Mod 4 - Cooranbong Coal Stockpile Extension (SSD-5145-Mod-4) – Surface Water Impact Assessment

Attachment 1 - CPHR Stormwater and Flooding Comments

Mod 4 - Cooranbong Coal Stockpile Extension (SSD-5145-Mod-4)

Figure 11. Conceptual layout of surface water management for the Modification

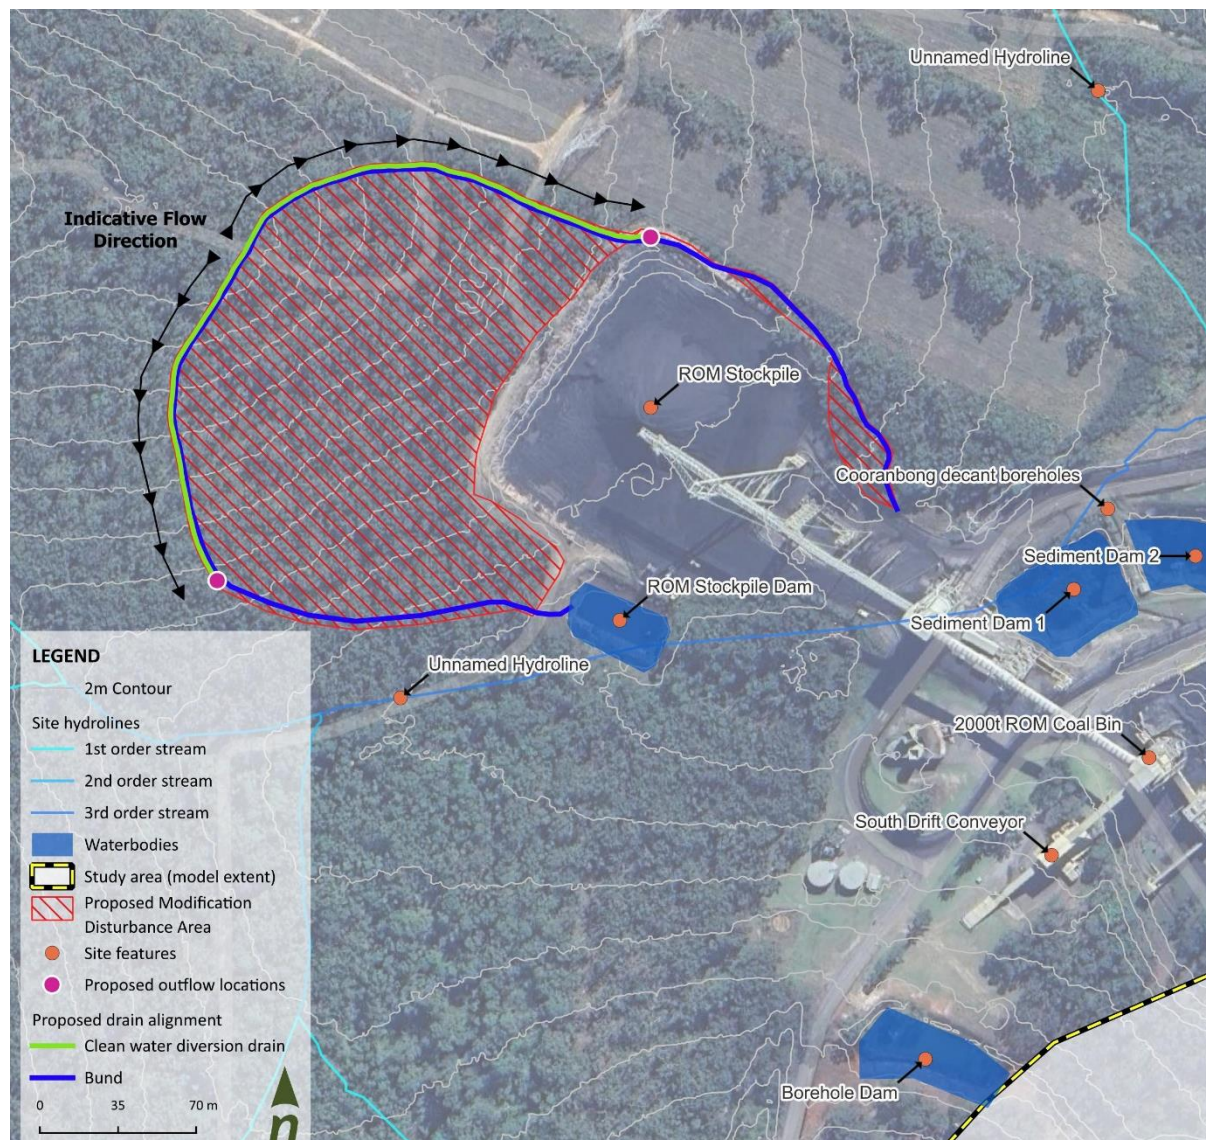
1.	<i>Frequency of dirty water overflows</i>	The proposed stockpile expansion area will result in an increase in dirty water runoff compared to existing site operations. The SWIA includes a water balance to assess whether this increased runoff can be managed within the existing water management system without resulting in additional discharges to the environment. The water balance results indicate there will be an expected increase in the frequency of daily spills from the ROM Stockpile Dam because of the proposed modification, increasing the number of annual spills from 1.1 to 11.7. As described in the SWIA, overflow from the ROM Stockpile Dam occurs via a manually operated valve and weir to Sediment Dam 1 and 2. To maintain controlled storage levels in these Dams, water is decanted to the Cooranbong Underground Storage through boreholes. These transfers aim to mitigate the risk of overflow from Sediment Dam 2 to licenced discharge location LDP001, during less frequent but larger rainfall events. Although the SWIA indicates that additional flow volumes can be “effectively managed within the framework of the current CES site water management system and are unlikely to result in any impacts to the downstream environment,” the water balance has not included a quantitative assessment of transfer between storages, including the capacity of boreholes or underground storages to accommodate additional flows. Recommended action: <i>The SWIA should be updated to include a quantitative assessment of the impact of increased spills from the ROM Stockpile Dam on water level management within Sediment Basin 1, Sediment Basin 2 and the Cooranbong Underground Storage, to determine if there will be a change in the frequency of overflows from Sediment Basin 2 to licences discharge location LDP001 because of the proposed modification.</i>

2.	<i>Potential reduction in water quality treatment time</i>	Sediment dams rely on extended settlement time to treat dirty water by removing pollutant laden sediments from runoff. The proposed modification will require increased movement of dirty water between different storages – ROM Stockpile Dam, Sediment Dam 1, Sediment Dam 2 and Cooranbong Underground Storage – to manage the additional volume of runoff generated from the proposed
----	--	---

stockpile expansion area. It is not clear if the movement of water between storages will impact on runoff settlement time and the treatment effectiveness of the sediment basins. Recommended action: <i>The SWIA should be updated to include a review of the required settlement times to effectively treat dirty water to confirm whether existing water quality treatment targets can be maintained.</i>
	<i>Extent and Timing</i>	Pre-determination

Figure 13. Flood model results – proposed depths (5% AEP maximum envelope)

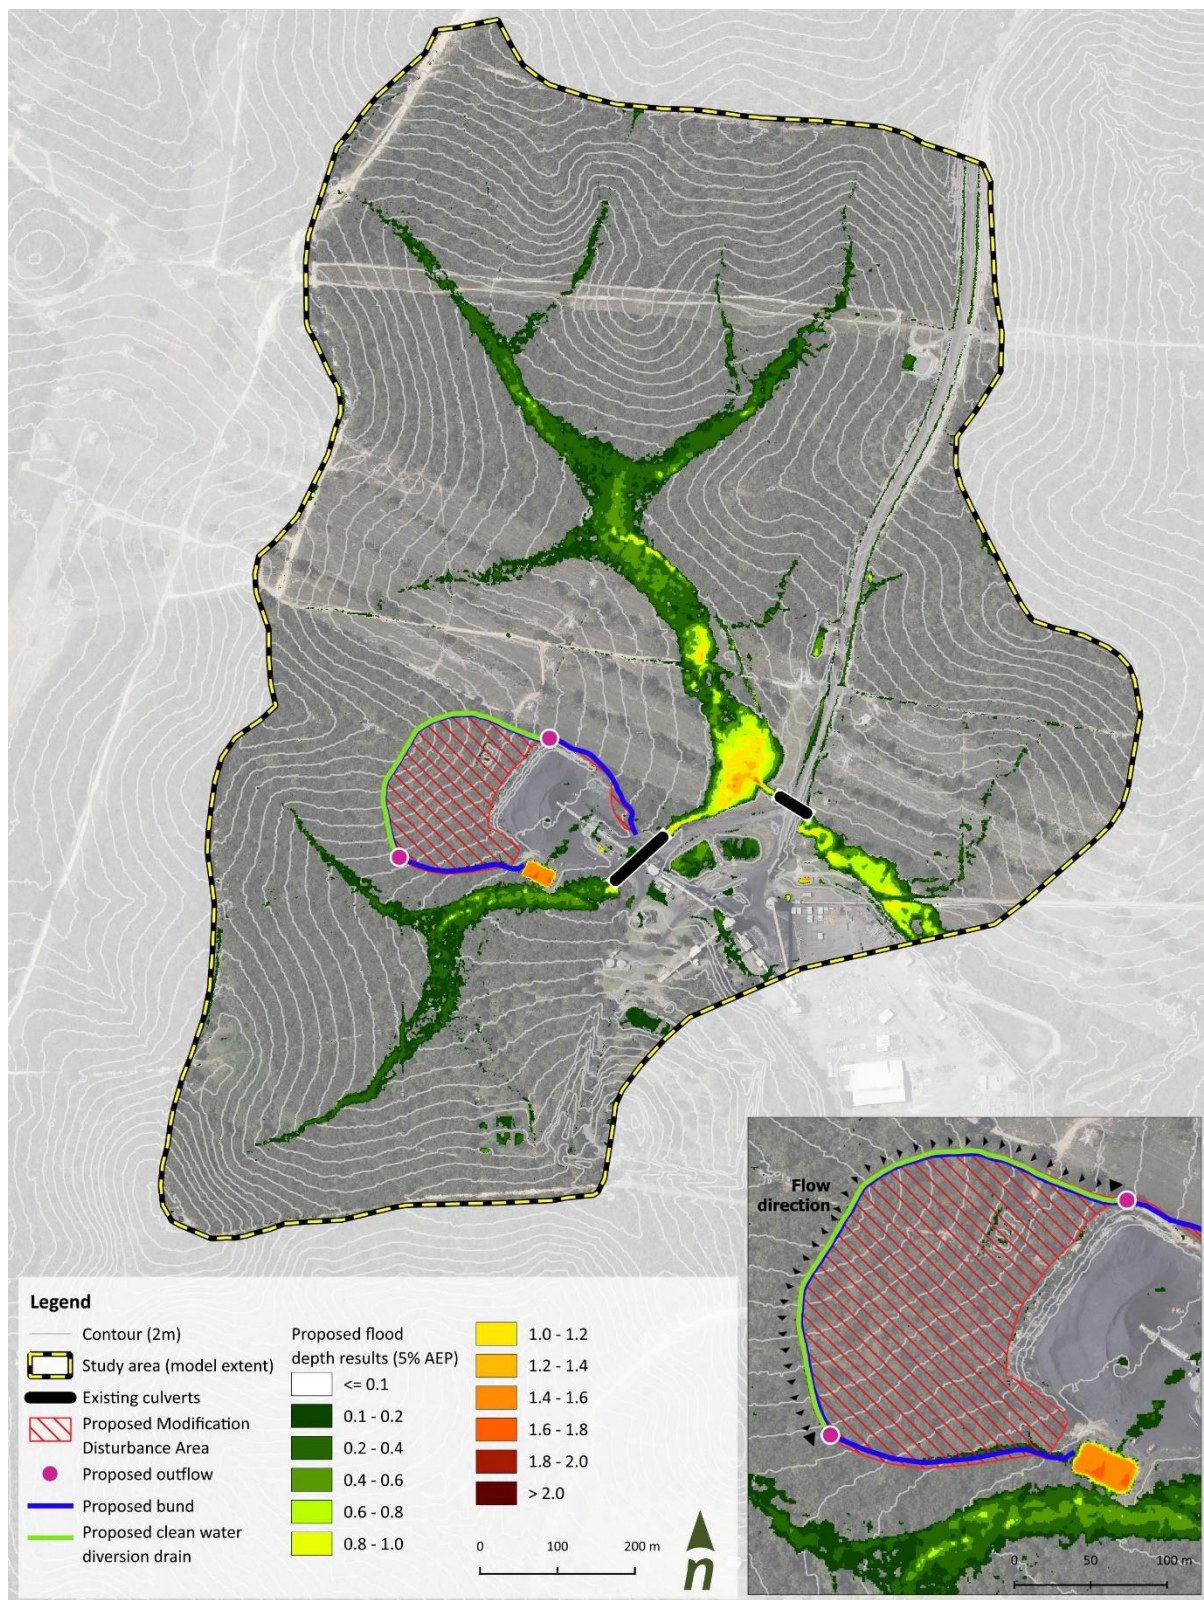
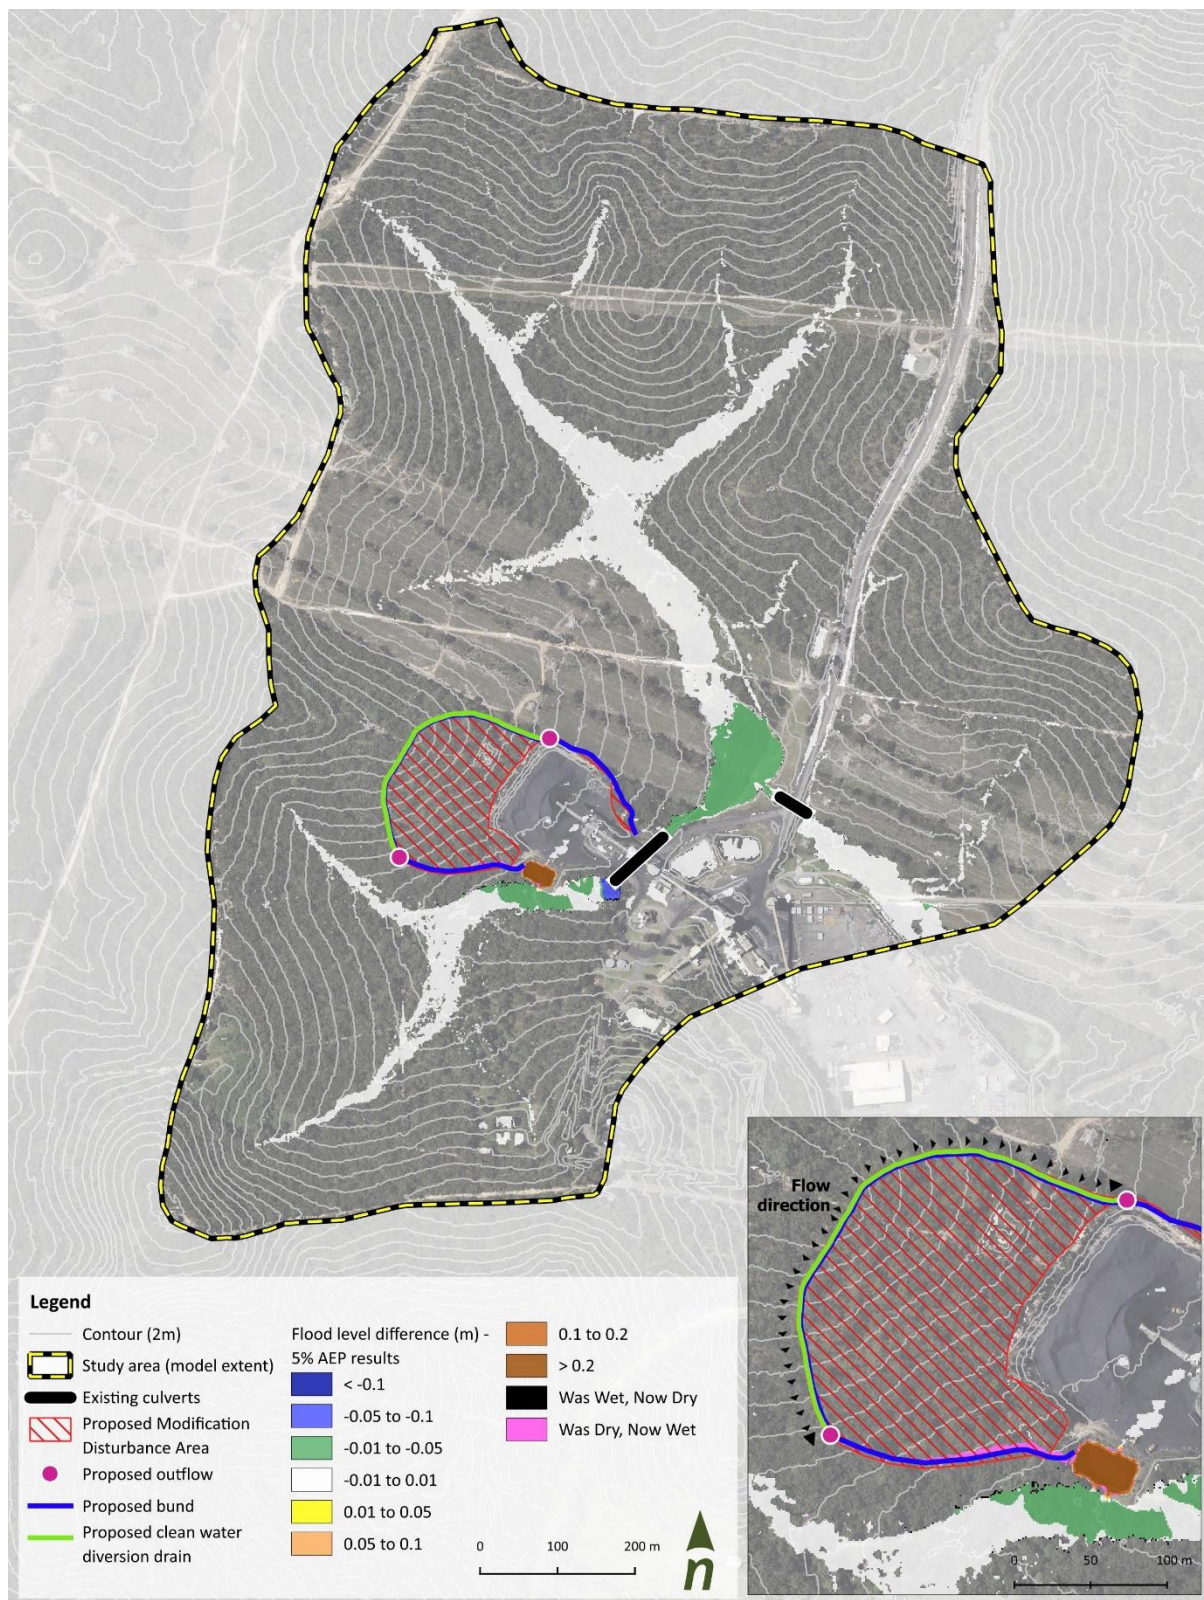
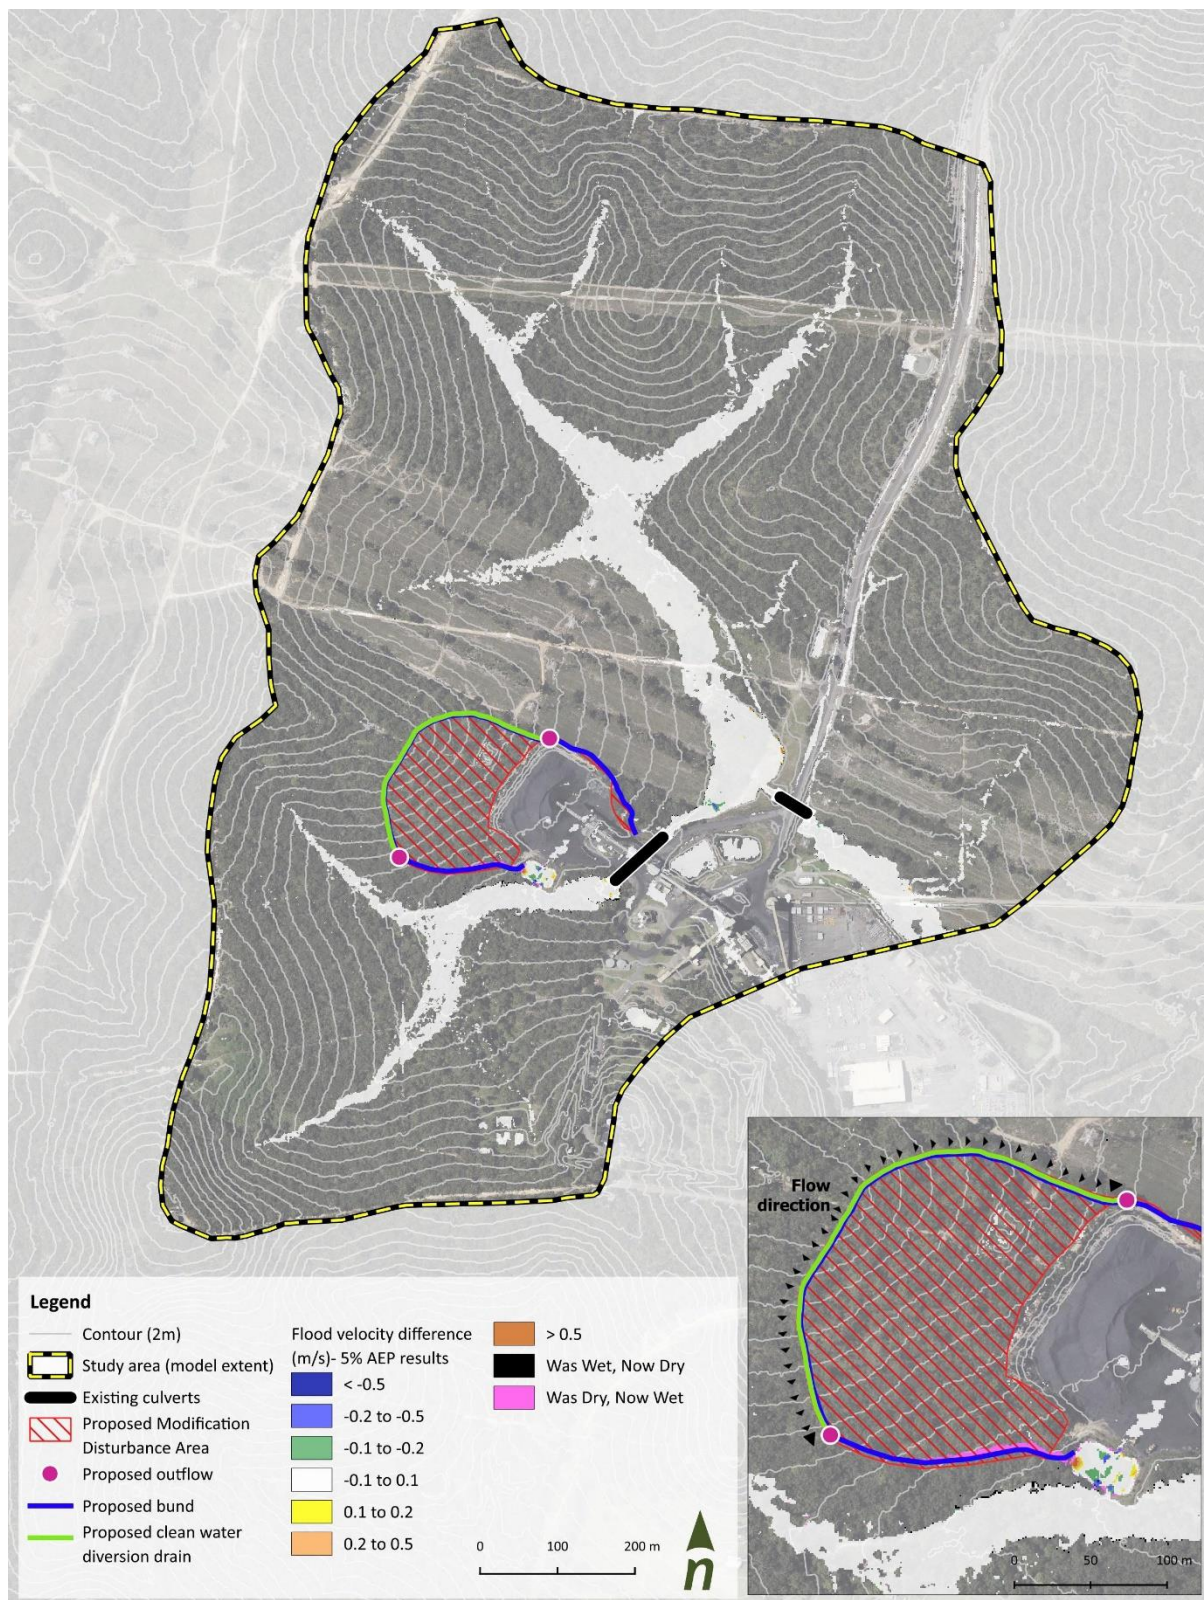
3.	<i>Preliminary flood impact assessment</i>	The SWIA includes preliminary flood modelling to evaluate the potential impacts of the clean water diversion on local hydrology and hydraulics. Key hydraulic controls within the area of interest include road crests, culverts and diversion drain. The model set-up and assumptions relating to these features (e.g. culvert capacity) mean modelled flood impacts are likely not representative of real-world conditions. Additionally, the flood impact assessment only includes one design event – the 5% Annual Exceedance Probability (AEP). No justification has been provided to explain why this event only was selected for the flood impact assessment. A range of design floods should be assessed to more completely understand the consequences of flooding on the business and community, as per Flood Risk Management Manual Guideline FB01 (NSW Government, 2023). Recommended action: <i>The SWIA should be updated to:</i> - <i>demonstrate the sensitivity of flood modelling results to assumptions relating to key hydraulic controls</i> - <i>simulate the 1% AEP design flood event, for existing and proposed development conditions to understand potential flood impacts both on and off-site for a range of design flood events.</i>
